WELWYN HATFIELD COUNCIL – DEVELOPMENT CONTROL
DELEGATED REPORT

APPLICATION No:	S6/2007/1418/FP
------------------------	------------------------

Drawing Title:
Proposed 2 Storey Extension
Proposed Floor Plans

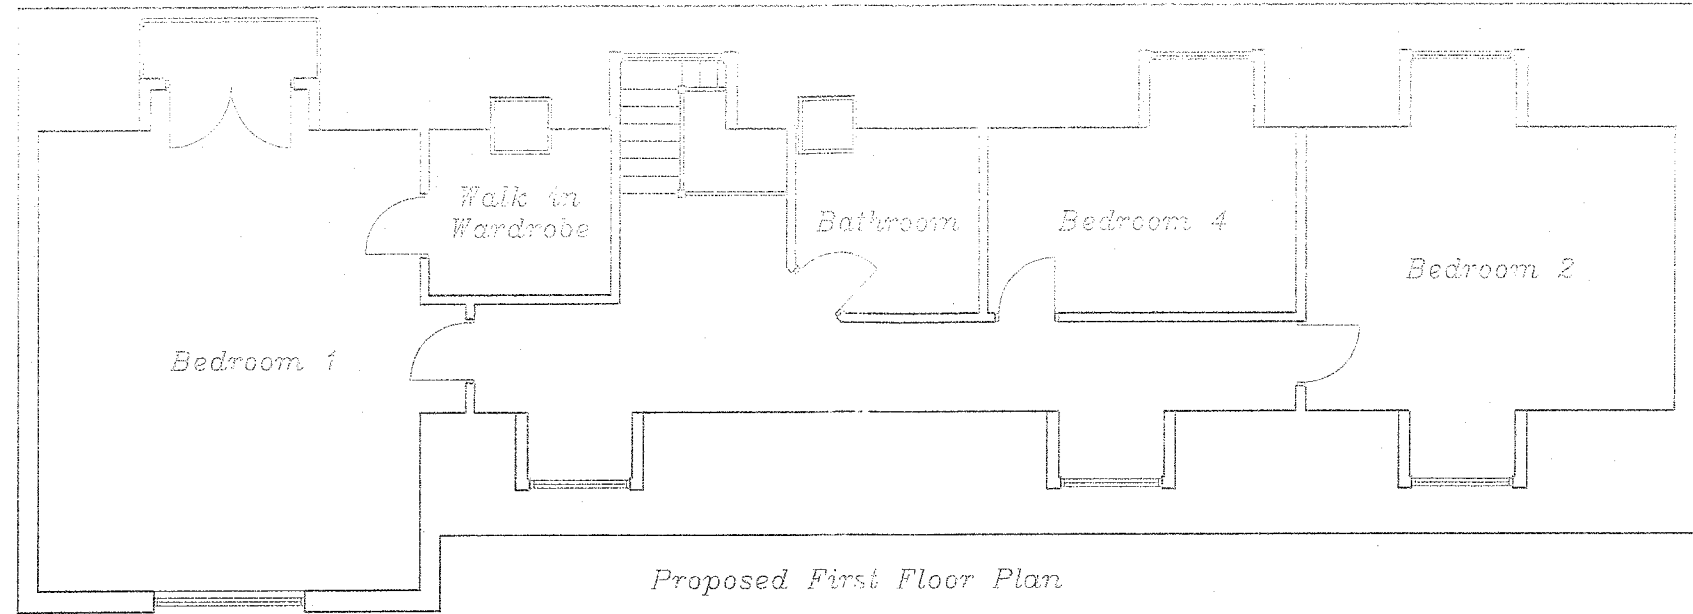
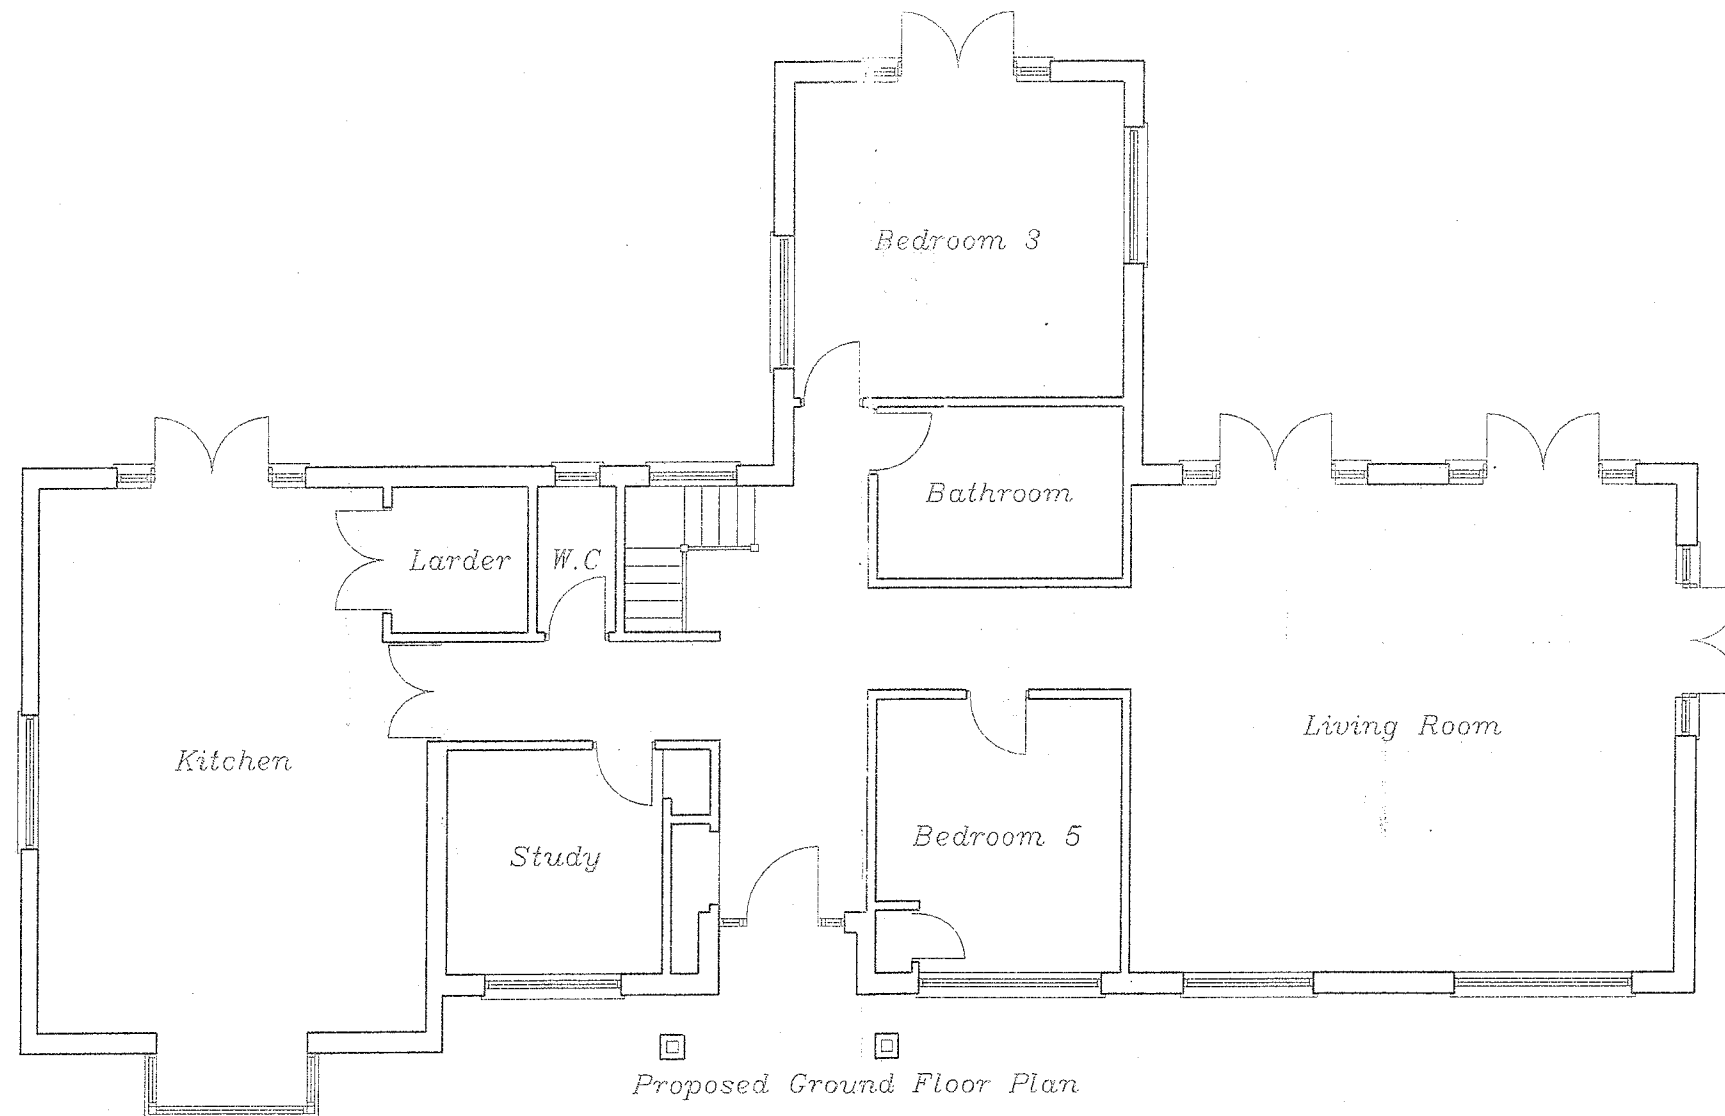
In addition, this planning application also seeks permission for a projecting ground floor bay which is approximately 2.3 wide and 0.9m deep and front porch with a pitched roof. Changes are also proposed to the arrangement of the window fenestration to the rear and to one side elevation.

The previous proposal equated to an increase of 36% over and above the original dwelling which is not considered excessive or disproportionate in floorspace terms, and the current proposal would increase this by around another 4sqm which would be a small percentage increase due to the ground floor bay projection and front porch. This additional floorspace would keep the percentage would not appear disproportionate when compared to the floorspace of the original dwelling. The changes to the window and door fenestration would also not result in any floorspace increase.

The porch and projecting bay are relevant as the other changes to the existing building were covered in the previous application.

The design of these additions would not be out if keeping with the resultant dwelling. The changes to the windows and door arrangement is also considered to be acceptable.

The existing property is considered for the purposes of Green Belt Policy to represent the ‘original’ dwelling. The cumulative increase in the sizes of the original dwelling that would result if the porch and projecting bay are added to that already approved would have an adverse visual impact on the openness of the Green Belt. This is taking into account that the earlier permission was close to the limit of what would be acceptable in terms of the limitations imposed by Green Belt Policy.

- 1. The proposal which is for additional extensions to those already approved by application S6/2006/1582/FP would, when considered cumulatively, result in a disproportionate increase in the size of the original dwelling due to its resultant appearance and from the increase in bulk and mass. This would diminish the openness of the Green Belt to the detriment of the rural character of the area contrary to the requirements of Policies RA1& RA3 of the Welwyn Hatfield District Plan 2005 and Planning Policy Guidance Note 2 (Green Belts). There are no very special circumstances which have been advanced to justify a departure from the Green Belt Policies of restraint.

Drawing Title:
Proposed 2 Storey Extension
Proposed Elevations

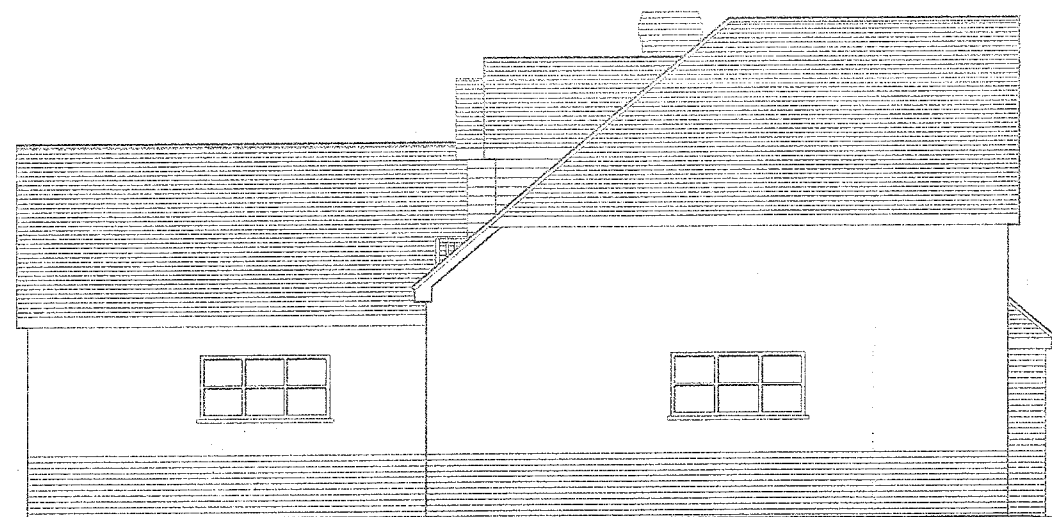
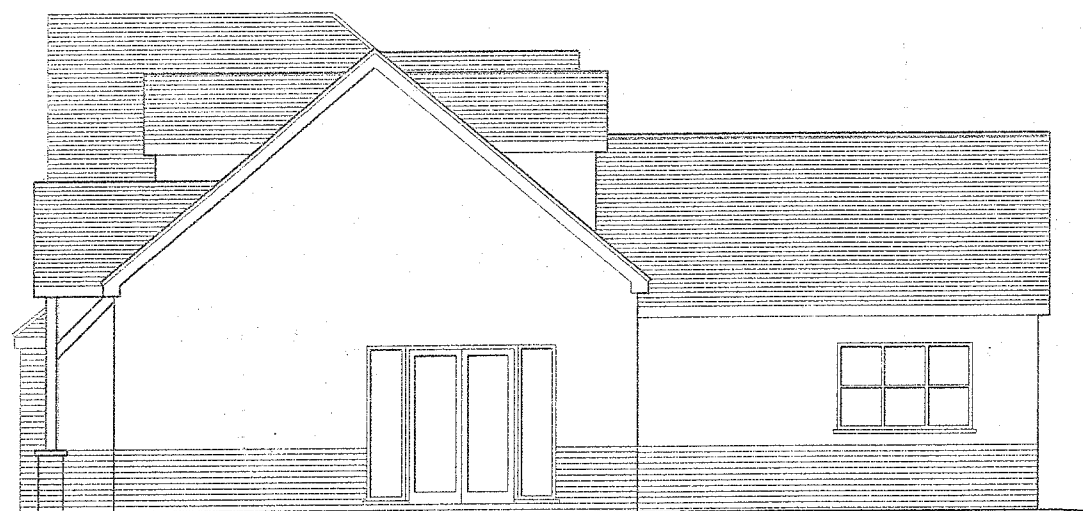
Turning to the overall visual impact of the proposal on the openness of the Green Belt, this is particularly important, as floorspace assessments in isolation may not suffice, as irrespective of the floorspace increase Policy RA3 also looks at the overall resultant size and its visual impact on the countryside. The approved changes (application S6/2006/1582/FP) are considered towards the limit of what would still comply with RA3, and the addition of a further pitched roof porch and ground floor projecting bay would be particularly noticeable, and more so than the slightly larger dormers and chimney proposed in application S6/2007/1418/FP. These additional changes would further impact on the visual openness of the Green Belt to an extent that, when taken into account those already permitted, the cumulative increase would be disproportional to the original dwelling.

The overall design of the dwelling, therefore, would have an adverse visual impact on the countryside and would represent an inappropriate form extension and so fails to comply with Policy RA3 of the Welwyn Hatfield Plan 2005 and the requirements of PPG2.
